CASCADE IRRIGATION DISTRICT

From: [Connor Armi](#)
To: [Zach Torrance-Smith](#)
Cc: [Guy Moura](#); [Hanson, Sydney \(DAHP\)](#)
Subject: Re: SP-24-00001 4G Farms - Notice of Application
Date: Tuesday, March 5, 2024 5:30:49 PM

TO: All Staff
FROM: Public Works Plan Review Team
DATE: March 20th, 2024
SUBJECT: Public Works Comments: SP-24-00001 4G Farms

RE: WDFW comments on SP-24-00001 4G Farms Short Plat

WALKER DRIVE SHORT PLAT
 PART OF SECTION 32,
 T. 18 N., R. 19 E., W.M.
 KITTITAS COUNTY, WASHINGTON

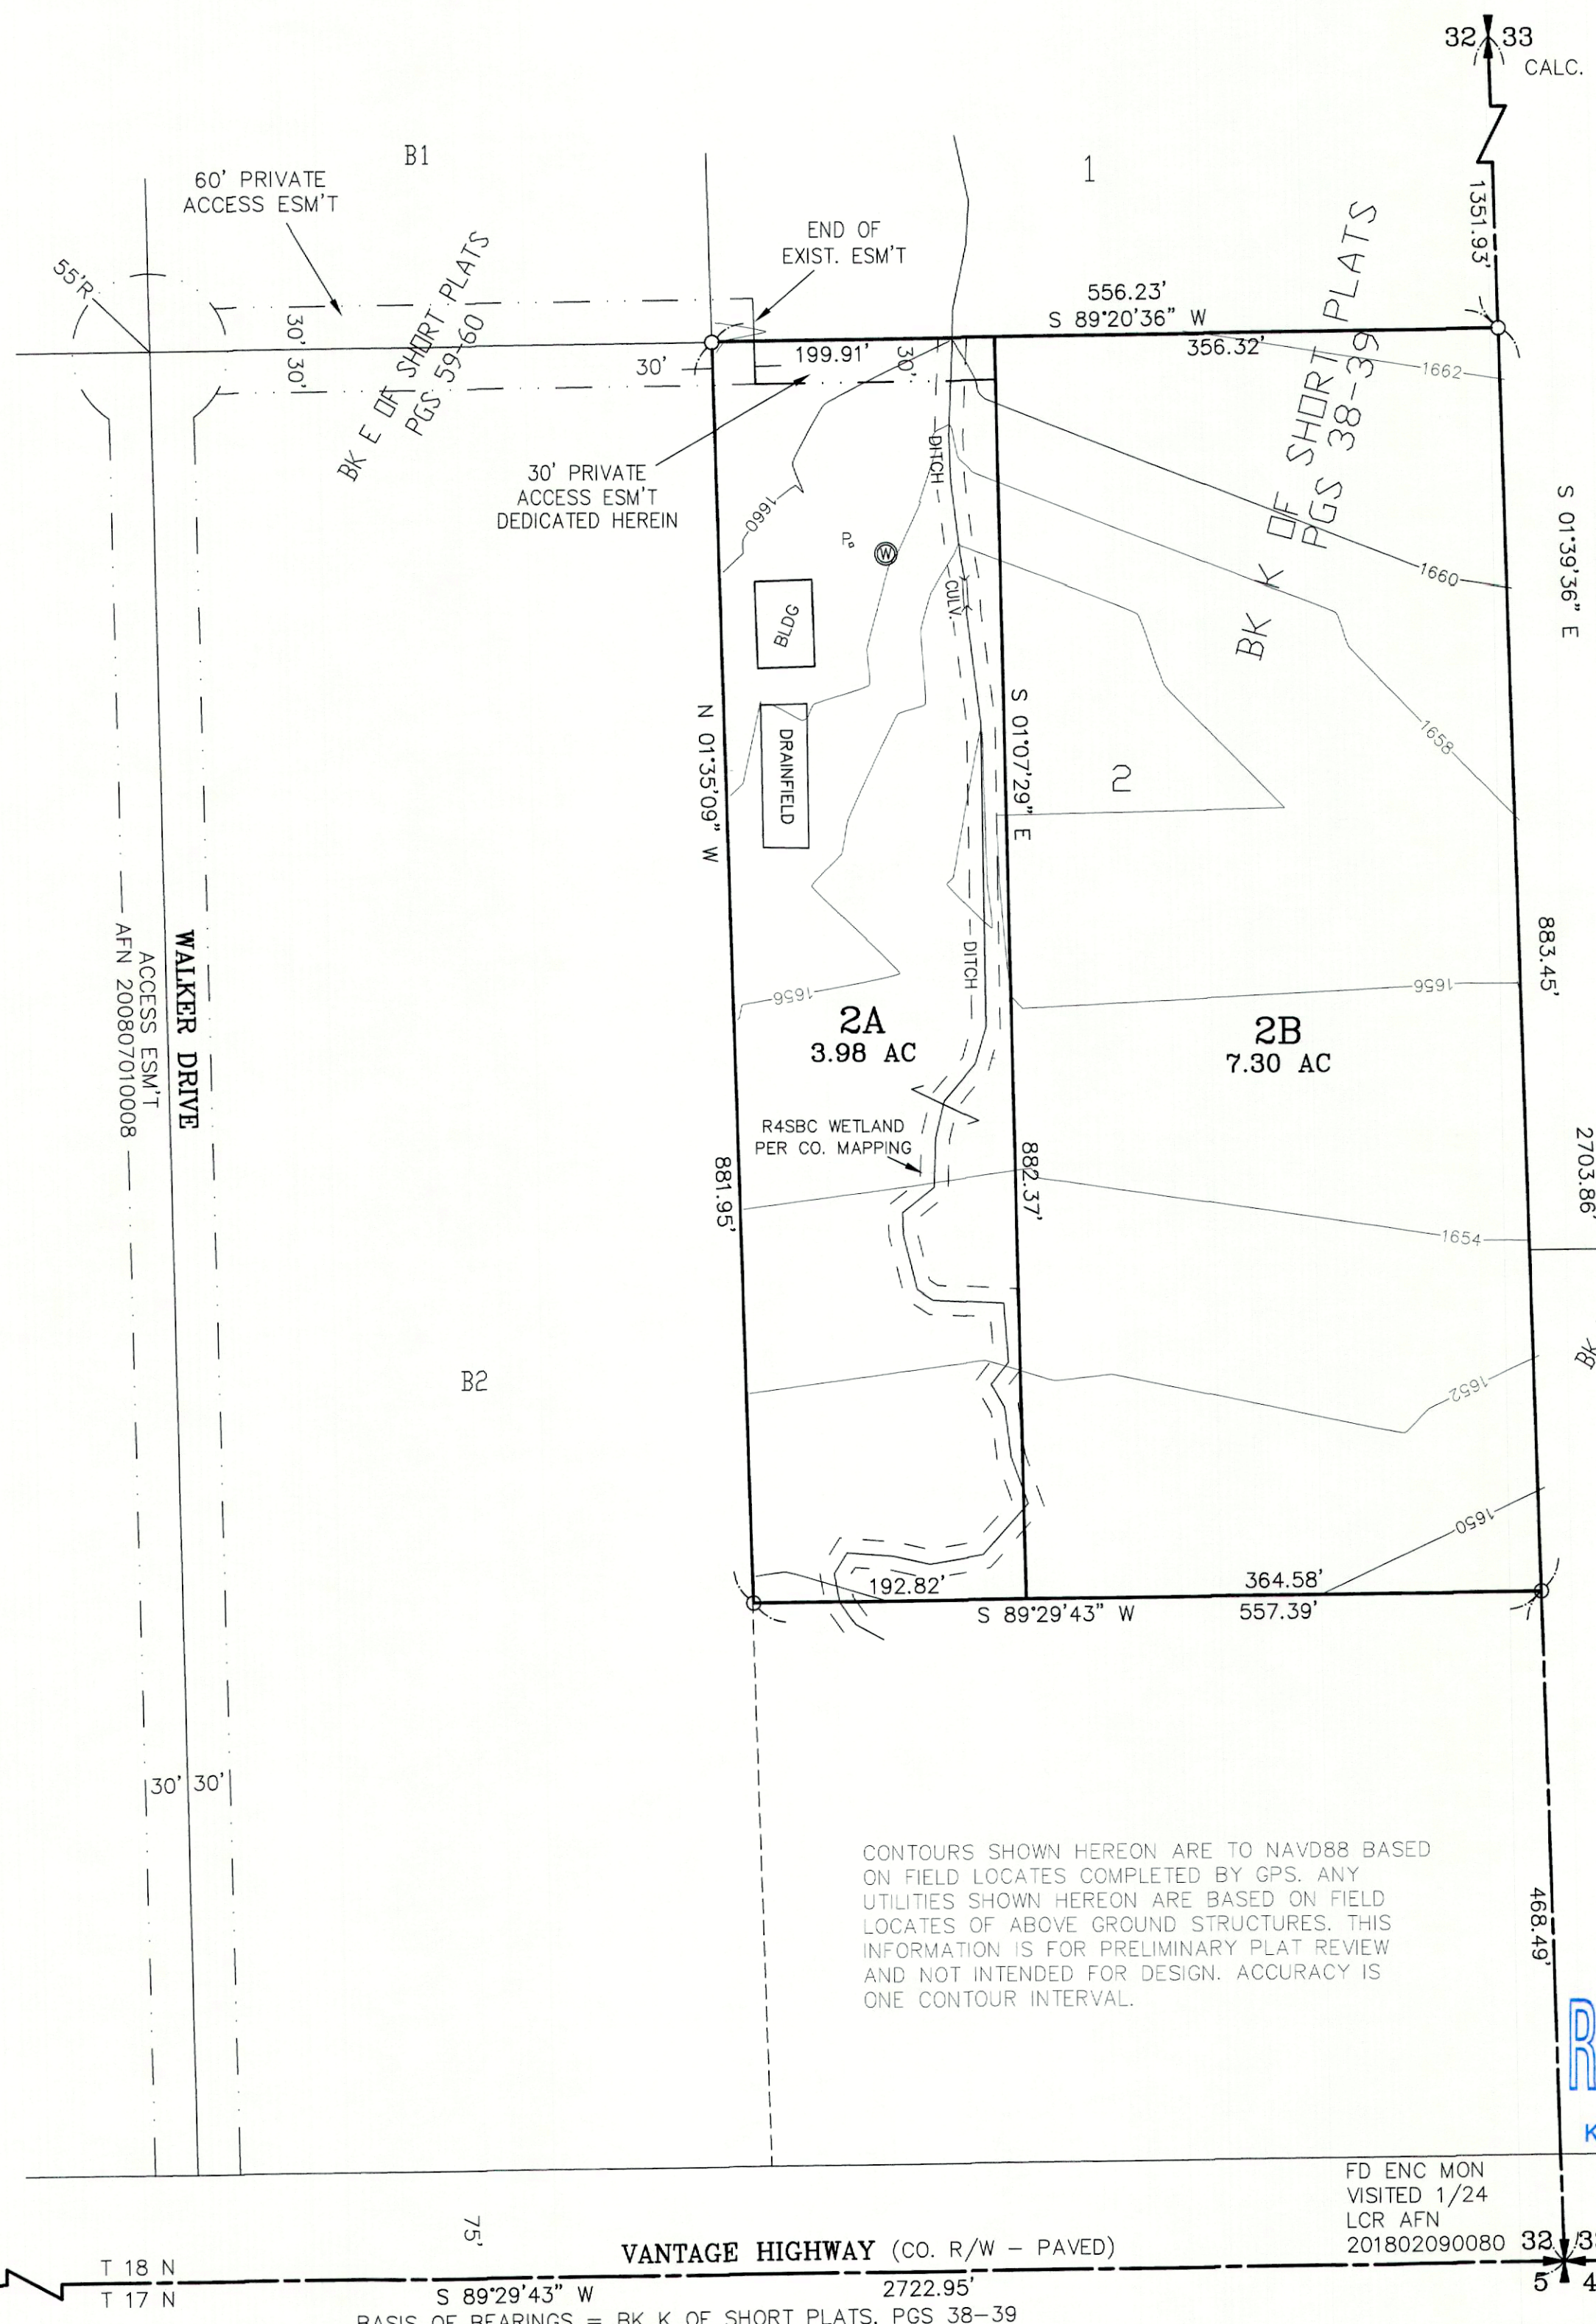
SURVEY	<p>Of note</p> <ol style="list-style-type: none"> 1. Easement from Walker Drive to property is unclear if it's a continuation of Walker Dr, an existing 60' easement or is to be created. 2. Found pin and cap but has no description for cap. <p>(KAH)</p>
TRANSPORTATION CONCURRENCY	<p>No transportation concurrency requirements for this project. (KAH)</p>
FLOOD	<p>Historic flooding data suggests that this property could be at risk of flooding. The current flood insurance rate maps (FIRMs) provided by FEMA do not reflect this risk. A flood permit is not required for the short plat. It is advised that any future development occurs on high ground away from the channel and that channel crossings are designed to be non-restricting to higher flows. (SC)</p>
WATER MITIGATION/ METERING	<p>The following comments outline the requirements for legal availability of water and metering for the proposed short plat:</p> <p>The applicant must provide legal water availability for all new uses on the proposed lots of this project, which can be provided through mitigation certificates. Prior to final plat approval and recording, the following conditions shall be met:</p> <p>In accordance with KCC Chapter 13.35.027, the applicant shall provide one of the following documents before final plat approval:</p> <ol style="list-style-type: none"> 1. A letter from a water purveyor stating that the purveyor has adequate water rights and will provide the necessary water for the new use; 2. An adequate water right for the proposed new use; or 3. A certificate of water budget neutrality from the Department of Ecology or other adequate interest in water rights from a water bank. <p>All applicants for land divisions shall also submit information on "proximate parcels" held in "common ownership" as those terms are defined in WAC 173-539A-030 and otherwise demonstrate how the proposed new use will not violate RCW 90.44.050 as currently existing or hereafter amended.</p> <p>Failure to obtain mitigation before commencement of an activity requiring mitigation shall be a code violation subject to enforcement under Title 18 KCC.</p> <p>Final Plat Notes</p> <p>The following notes shall be placed on the face of the plat:</p> <p>C-1 "Metering is required for all new uses of domestic water for residential well connections and usage must be recorded in a manner consistent with Kittitas County Code Chapter 13.35.027 and Ecology regulations."</p>

Mapping produced during the County's [Wilson-Naneum-Cherry Assessment](#) show Little Naneum Creek originating north of the project area and Cascade Canal, and flowing southerly through the property and called out in the preliminary short plat map as "Ditch", near the proposed new parcel boundary. Little Naneum Creek is a distributary channel west of the mainstem Naneum Creek. Little Naneum Creek flows year-round through most of its length and is a fish bearing stream. Ensuring Little Naneum Creek is correctly identified as a fish bearing stream in this short plat process will protect the functions and values of this important critical area.

As part of the short plat process, future building and septic locations for new parcels should be considered such that the critical areas can be protected along with future infrastructure without the need for future variances from the critical areas regulations. We appreciate the opportunity to comment and work with the proponents to meet their needs. Please feel free to contact me at (509) 961-6639 or Jennifer.nelson@dfw.wa.gov if you have any questions about these comments.
